Your reference: SSD-8950984
Our reference: DOC23/993628

Heritage NSW - Advice on Environmental Impact Statement (EIS) - State Significant Development (SSD-8950984) – Burrendong Wind Farm

11 December 2023

Figure 5: Road access upgrades proposed at intersection of Yarrabin Road/Burrendong Dam Road

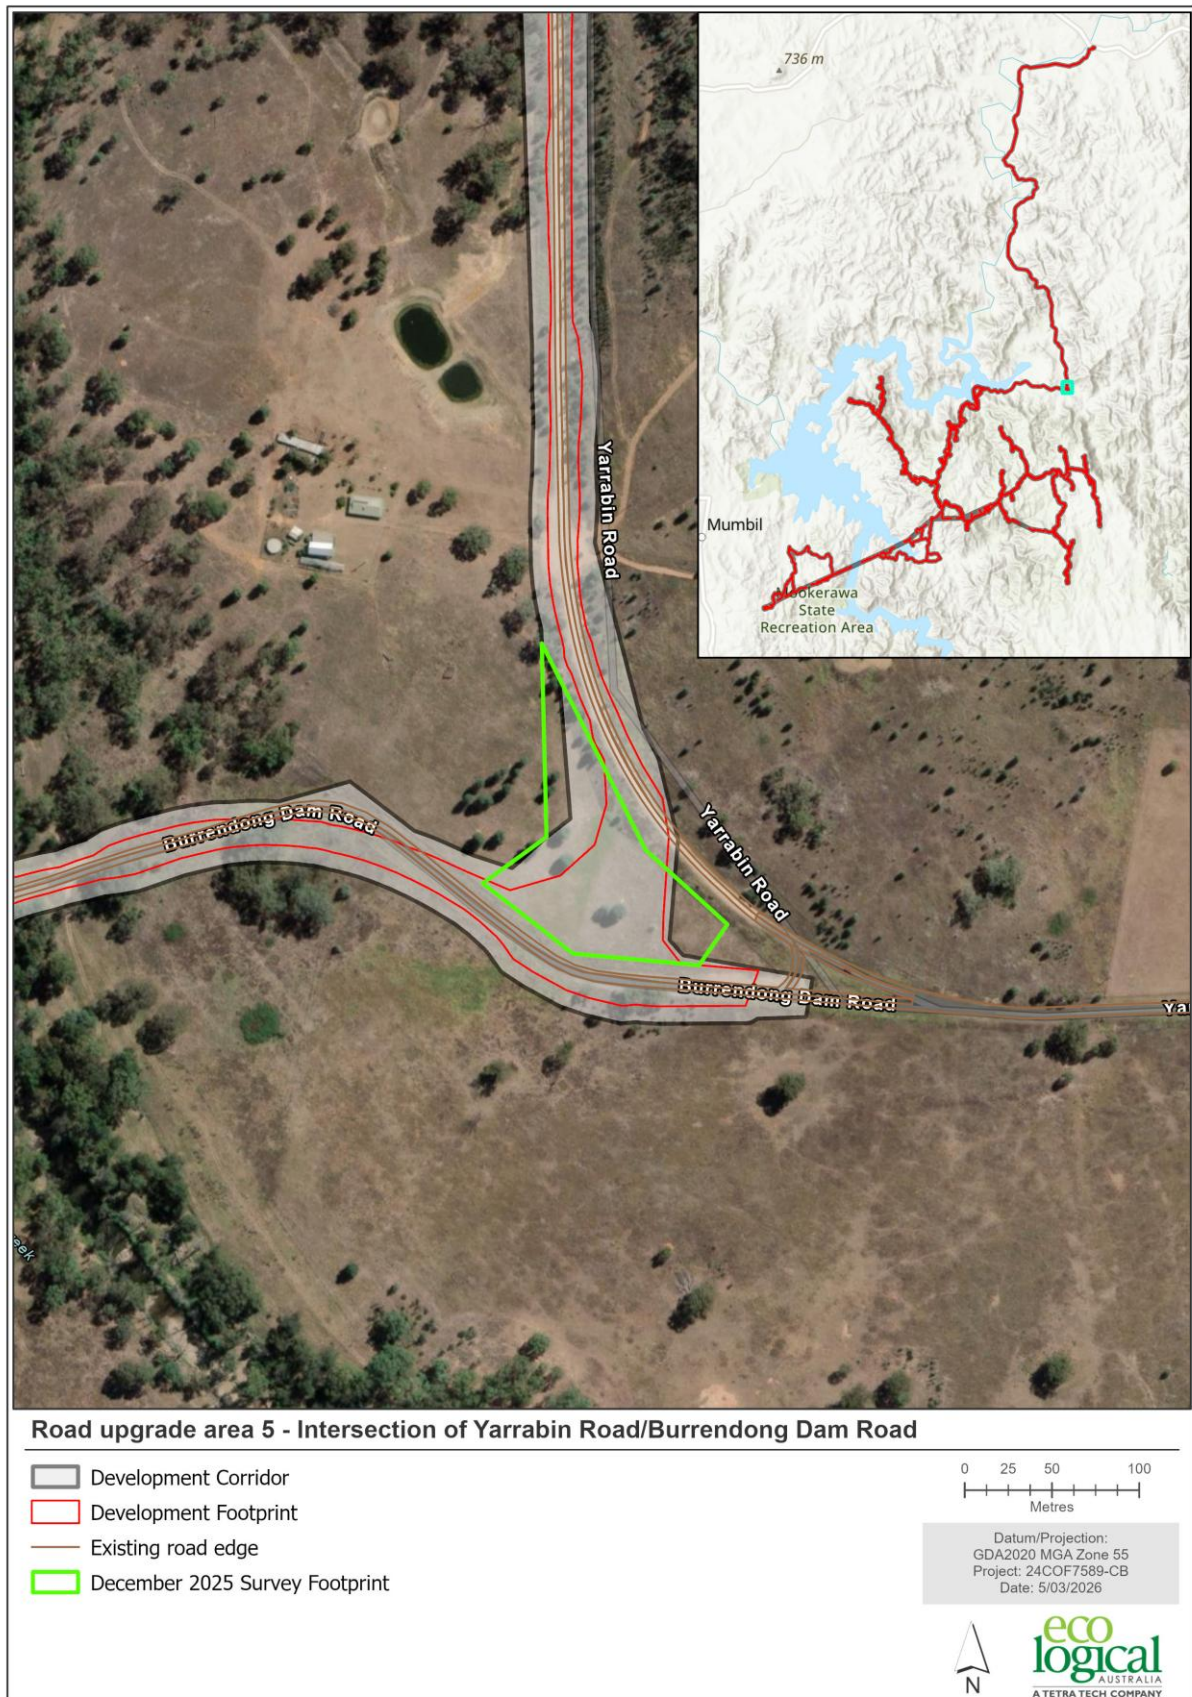
- The footprint of works identified in the EIS includes a transport corridor subject to road upgrades. Please clarify if the approval for these impacts is a part of SSD 8950984, as the ACHAR did not include these areas within the assessment. If the transport corridor works are a part of the SSD 8950984 approval, they will need to be included in the Aboriginal Cultural Heritage Assessment.
- Section 6.8 of the EIS states 94 of the 102 sites identified on the AHIMS search were located in the assessment area. This is in contrast to Section 4.1 of the ACHAR which states not sites are within the project site. Please clarify this information.

Figure 47: Survey coverage and results – road upgrade area 1

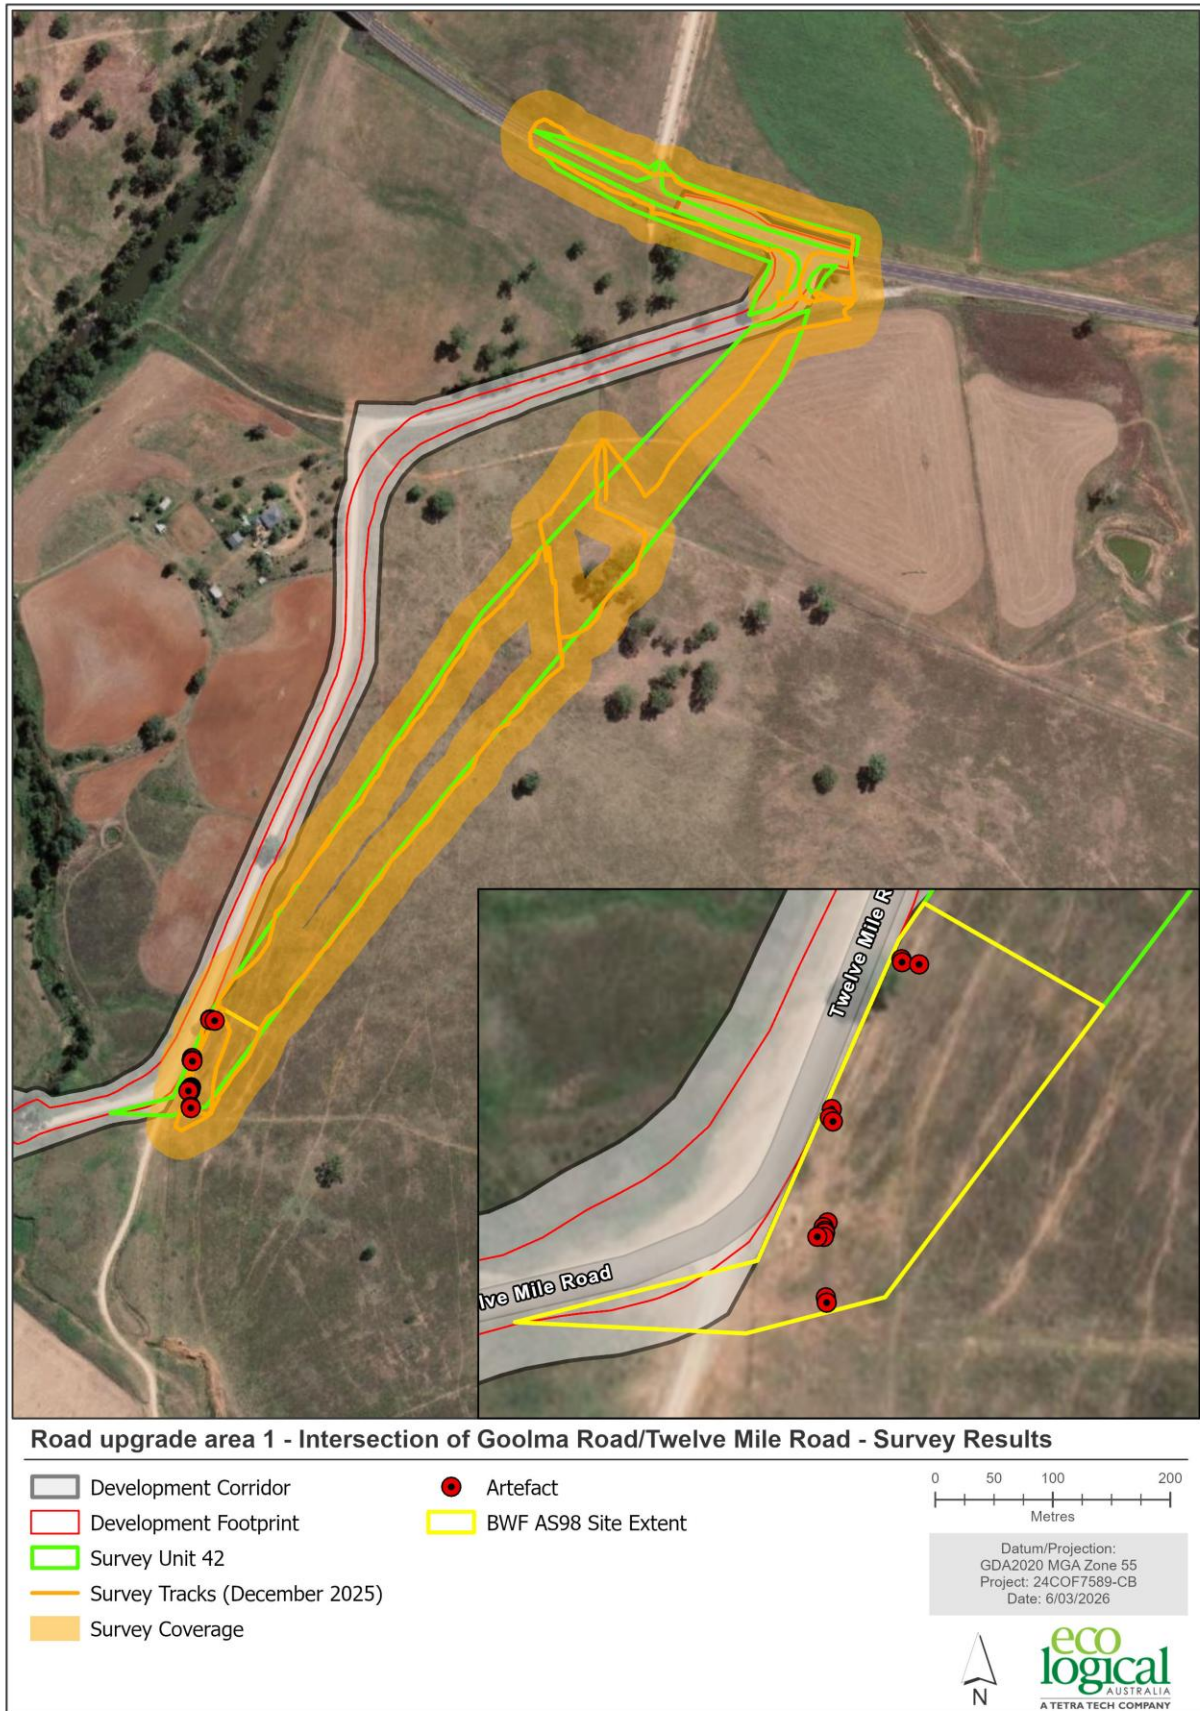
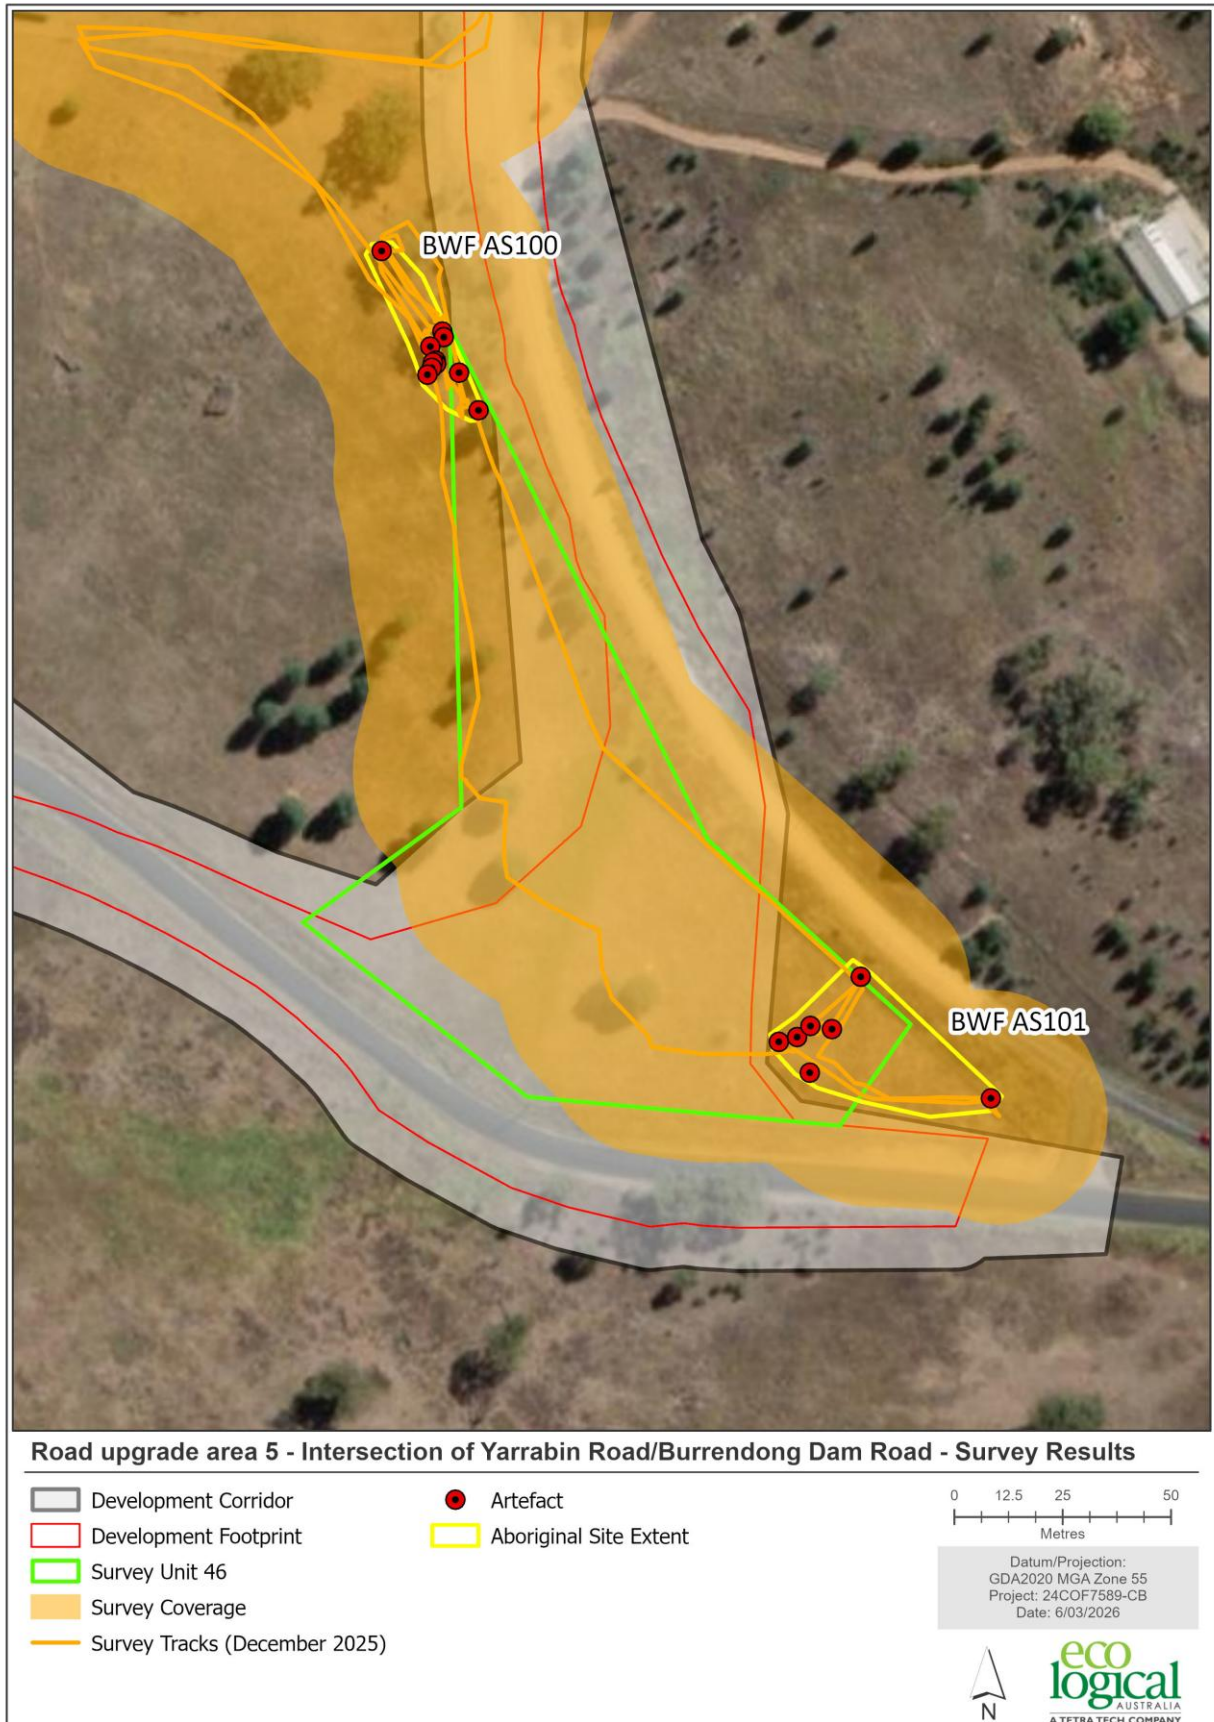
- Please clearly identify those areas that were subject to the pedestrian survey.
 - Please provide detailed and thorough mapping which includes survey track logs, as per Requirement 5 of the *Code of Practice for Archaeological Investigation of Aboriginal Objects in NSW* (2010), to enable Heritage NSW to assess the efficacy of the survey coverage.
